WEST SUSSEX COUNTY COUNCIL CONSULTATION

TO:	Arun District Council FAO: Mr. S. Davis
FROM:	WSCC – Highway Authority
DATE:	21 January 2025
LOCATION:	Land adjacent to Woodgate Nurseries Lidsey Road Aldingbourne PO20 3SU
SUBJECT:	AL/143/24/RES Approval of reserved matters following outline consent AL/129/21/OUT for 95 No residential dwellings with associated parking, landscaping, open space (including play areas), infrastructure and works. This application is in CIL Zone 3 and is CIL Liable as new dwellings.
DATE OF SITE VISIT:	n/a (desktop study undertaken – site visited at outline stage)
RECOMMENDATION:	Modifications Recommended

This is the WSCC Highways response to the above planning application seeking approval of reserved matters following outline consent AL/129/21/OUT for 95 No residential dwellings with associated parking, landscaping, open space (including play areas), infrastructure and works.

Small Single Garage - Plans & Elevations (1:50)

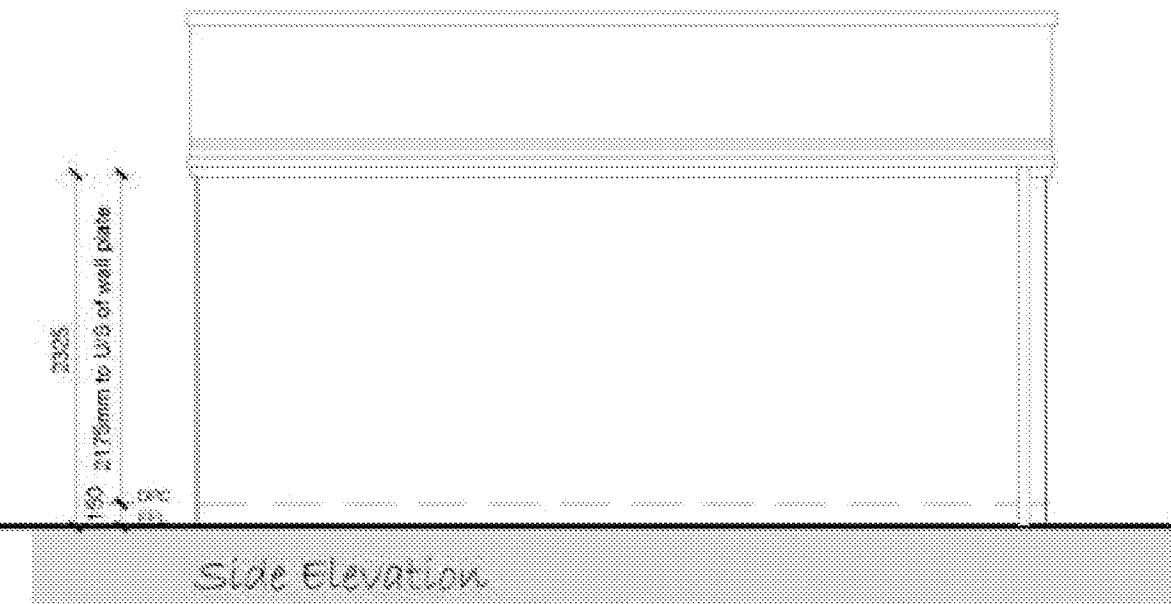
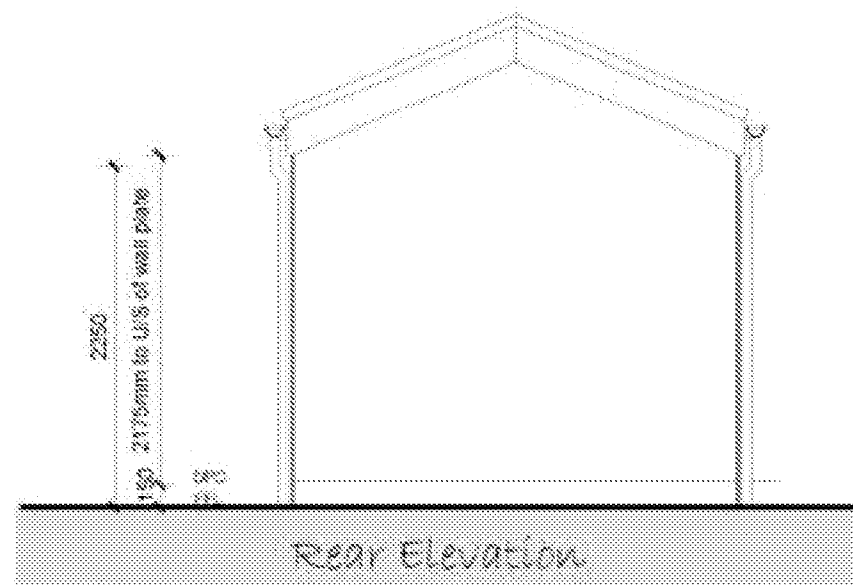
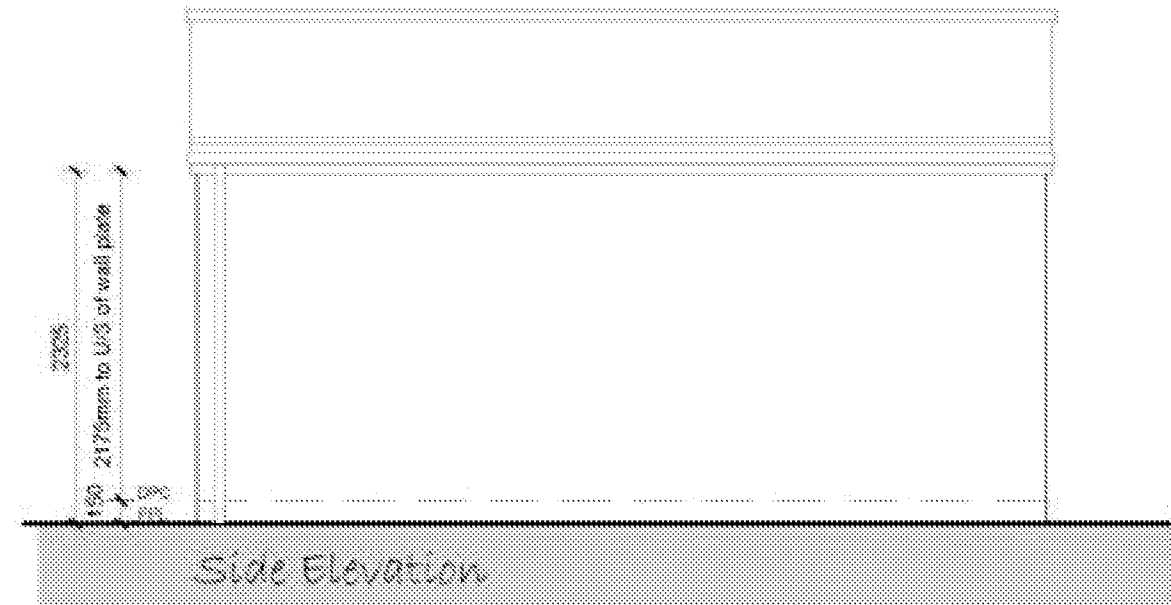
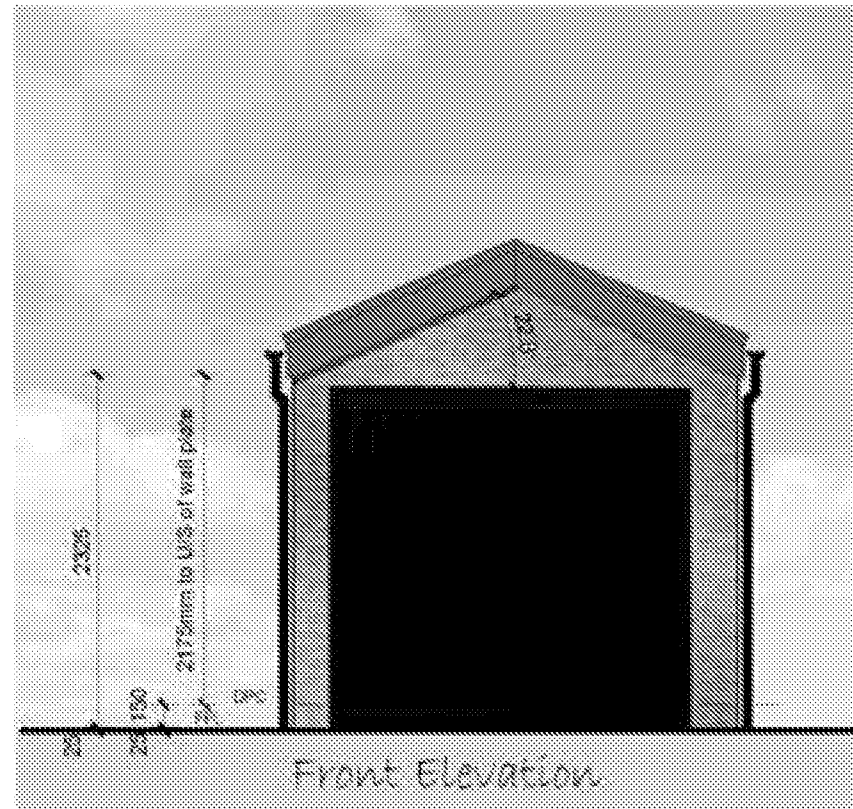
- The small garage sizes are not in accordance with Manual for Streets (MfS) recommended sizes. Applicant to amend.
- Tabletop area adjacent to plots 36-44 conflicting with some driveways. Applicant to see if this can be altered to remove the conflicts.
